Response to Submission for Kemps Creek Warehouse, Logistics and Industrial Facilities Hub (SSD 9522)

Response to Submissions – Kemps Creek Warehouse, Logistics and Industrial Facilities Hub (SSD 9522)

Response to Notice of Amended Plans and Amended Supporting Information for Kemps Creek Warehouse Logistics and Industrial Facilities Hub (SSD 9522)

02 PROPOSED DISTRIBUTER ROAD - SECTION AA
SCALE - 1:200 @ A1

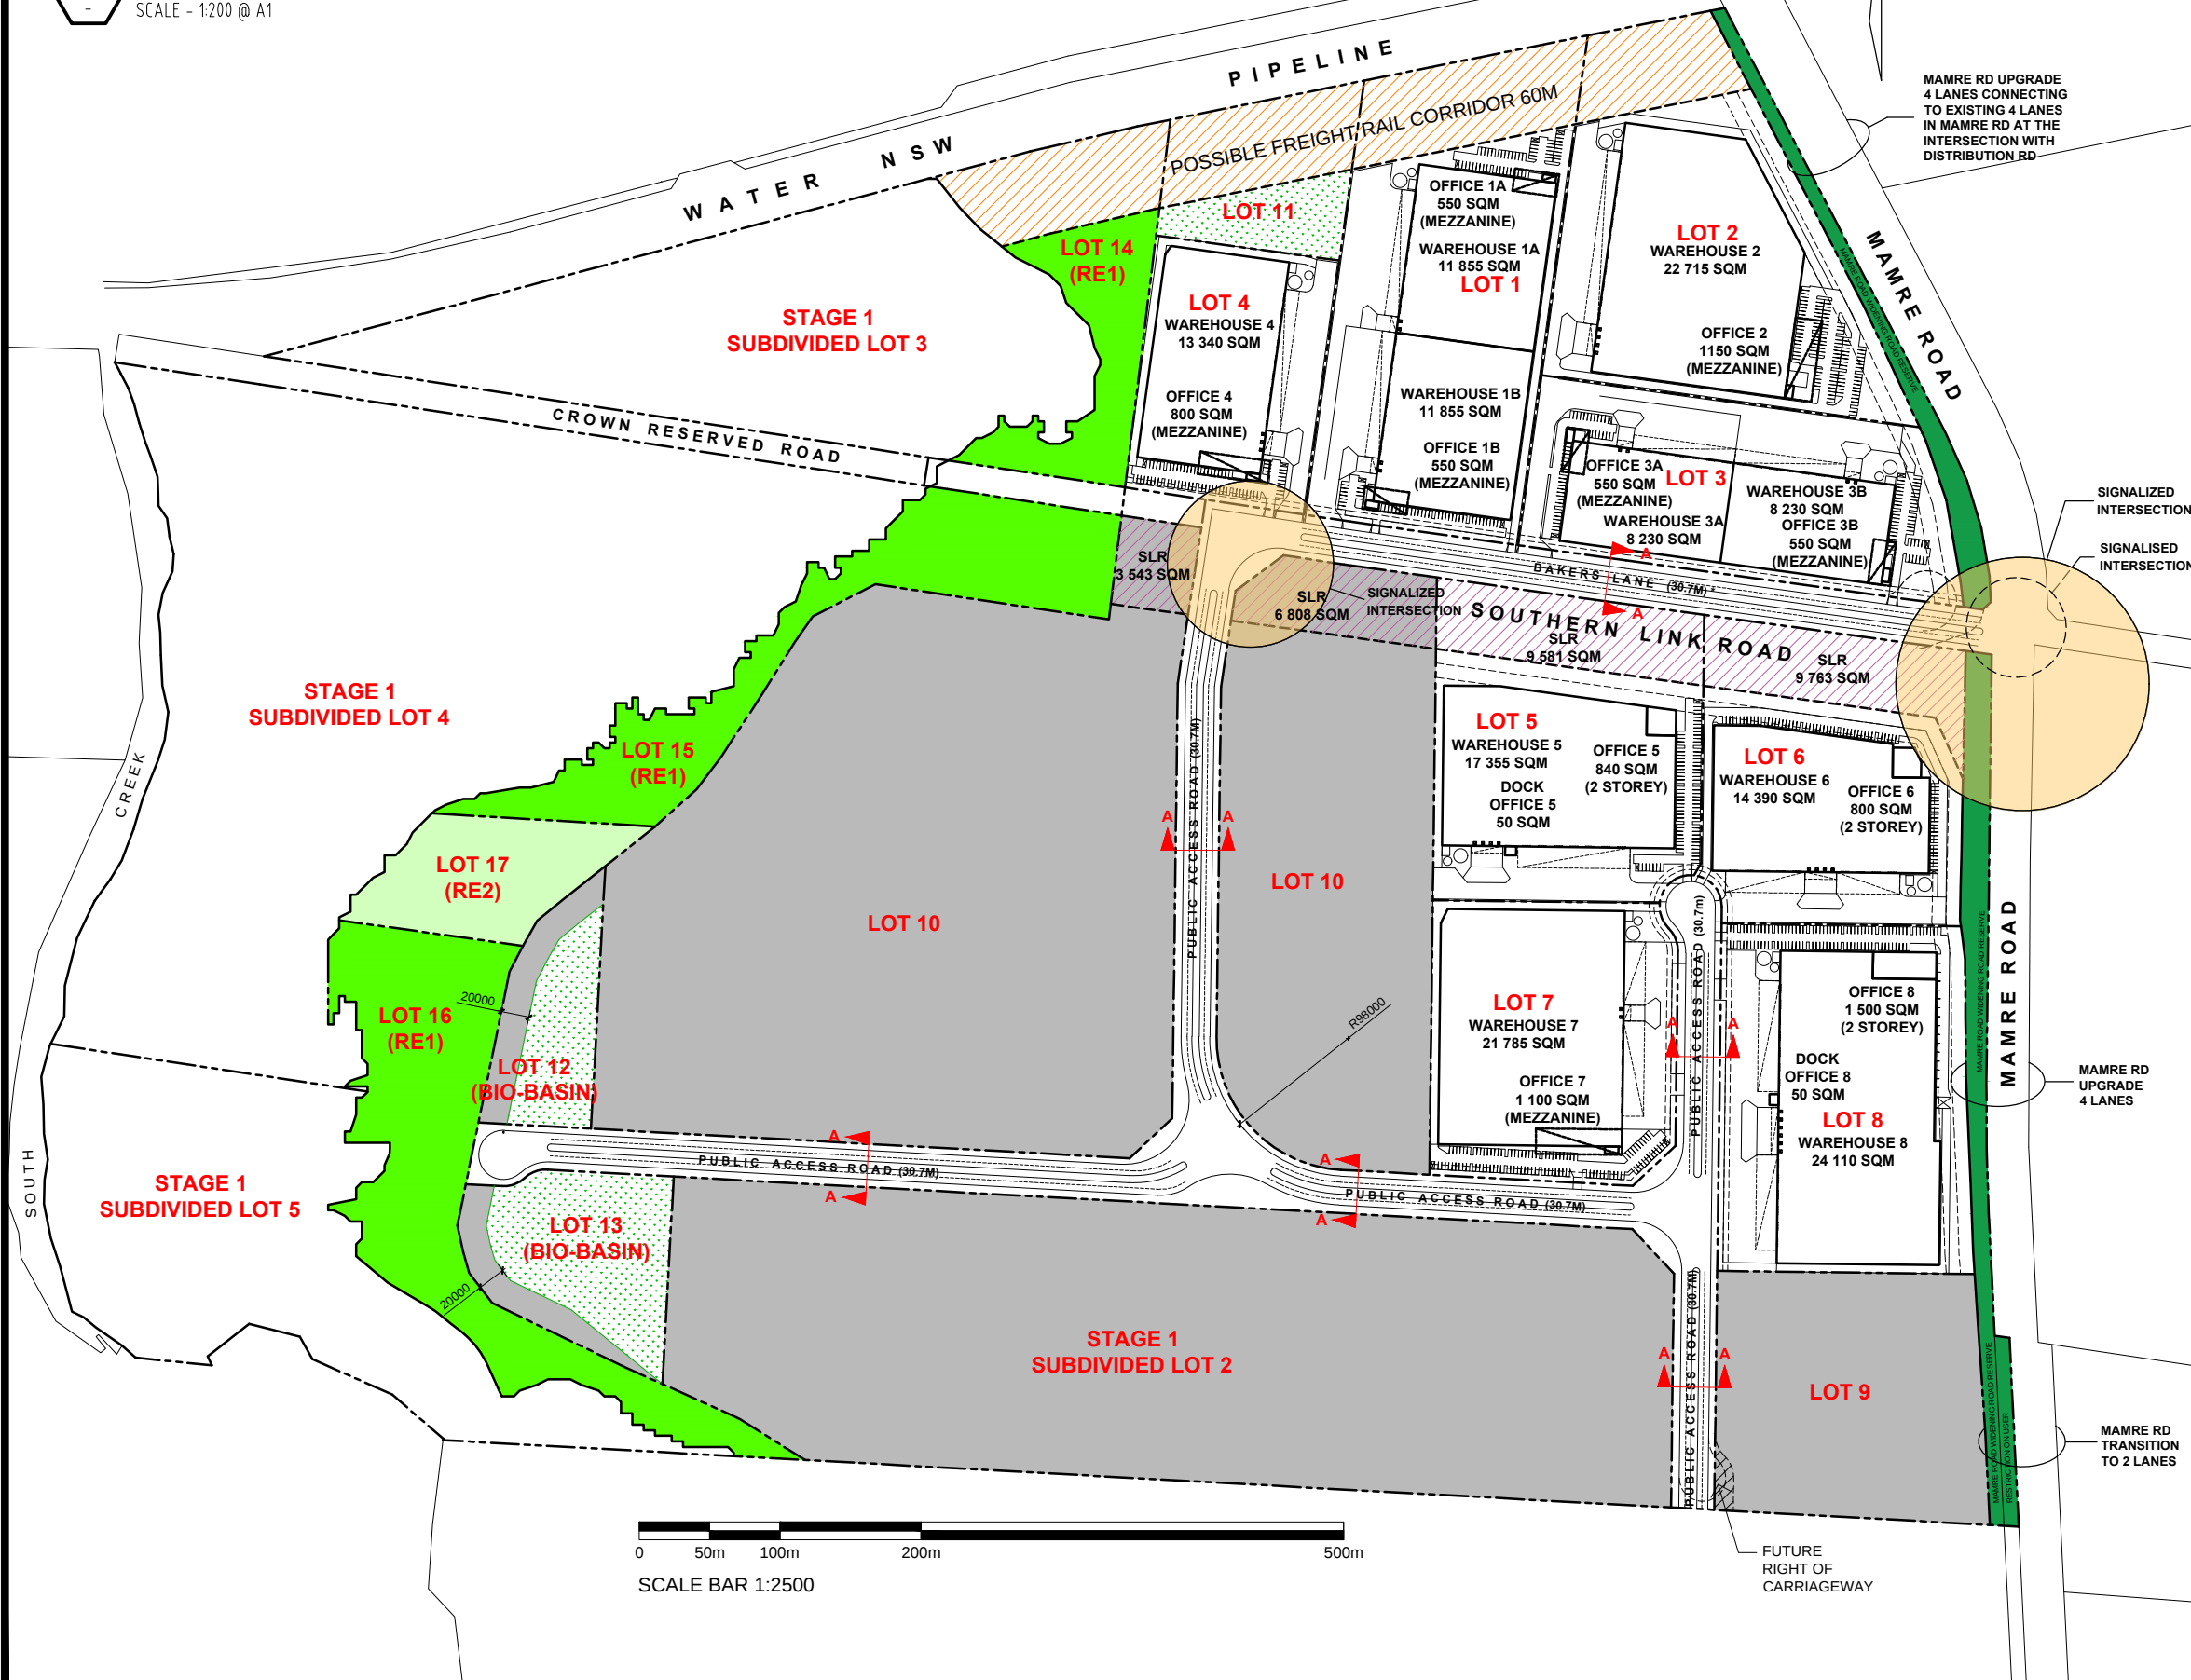
The amended Subdivision Master Plan provides a Section A-A which implies that a road reservation is intended between the bio-basin lot and RE1 zoned land. The plan of subdivision however does not identify a road in this location and the verge widths as indicated in the Section Drawing are of concern. Section A-A on this plan should be deleted from the Subdivision Master Plan as it is assumed to be in error.
